Brewery Road Apartments, Stillorgan, Co.
Dublin

Stormwater Audit Stage 1

August 2019

Document Number: 192-206-SWA-S1

PROPOSED HYDROBRAKE MANHOLE SMH8  
SCALE 1:25

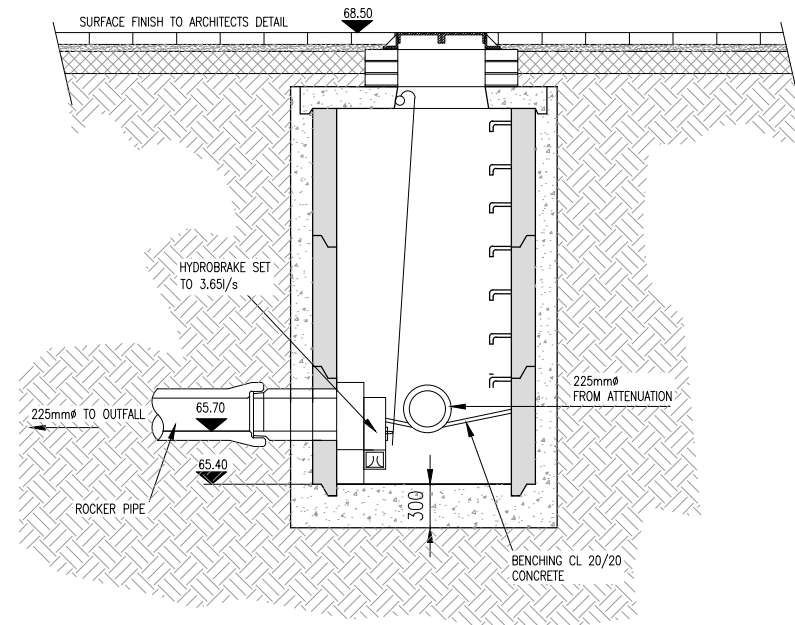
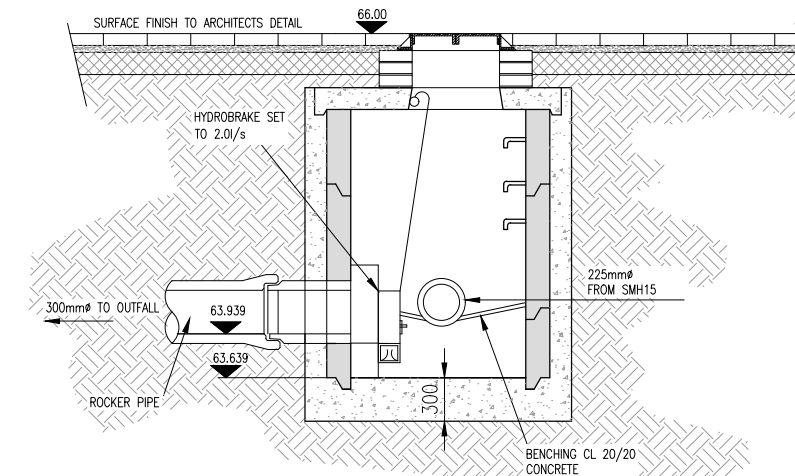
Problem: Hydrobrake details (orifice size, make and model) not submitted

Recommendation: It is also noted that the orifice size of the Hydro-Brake required is 53 mm, which is not considered practical for maintenance. We do not recommend use of a flow control device with an orifice below 75mm diameter. If a larger diameter is not achievable, please confirm what procedure will occur to prevent flooding in the case of a blockage. Consider installing a sediment reduction/removal device (such as a Downstream Defender or equivalent) upstream of the Hydro-Brake.

Problem: Hydrobrake details submitted differ between drawings and Engineering Report. Engineering Report states total discharge of 5.65 l/s, drawings call off both flow controls as 2 l/s each.

Recommendation: Please Clarify the discharge of the 2 no. hydrobrake being provided.

DETAILS OF PROPOSED NSBP006 KLARGESTER BYPASS  
PETROL INTERCEPTOR IN LANDSCAPING AREA  
SCALE 1:25

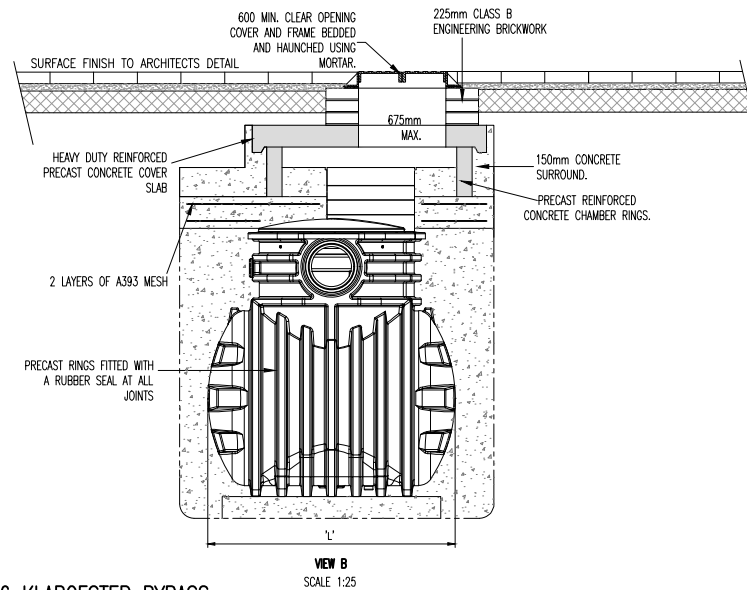
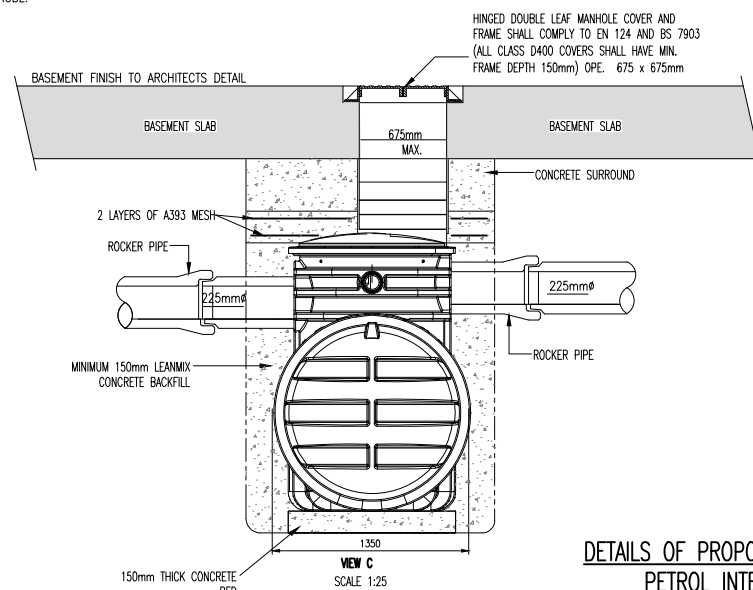
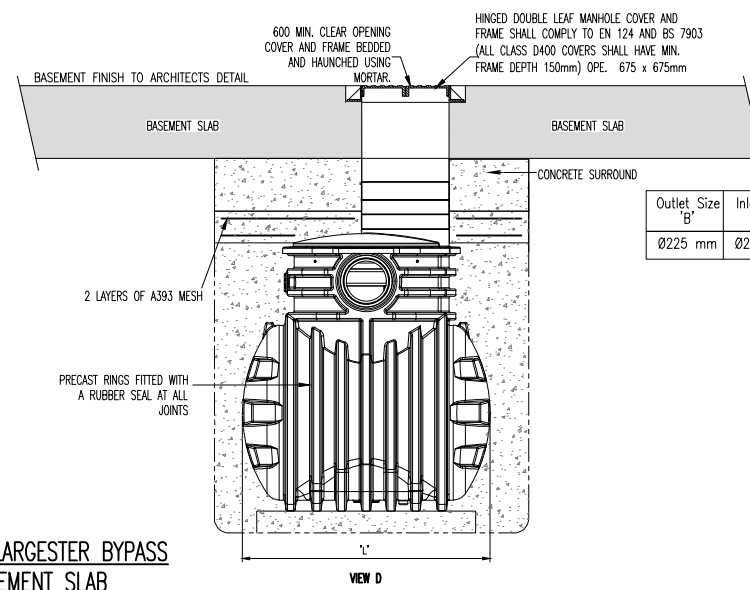
Problem: Bypass Interceptor details provided only refer to the basement interceptor.

Recommendation: Please confirm if the Petrol interceptor to the North of Block N is to be the same as the Interceptor being provided in the basement. If not, please provide details of the Petrol Interceptor to be provided at this location.
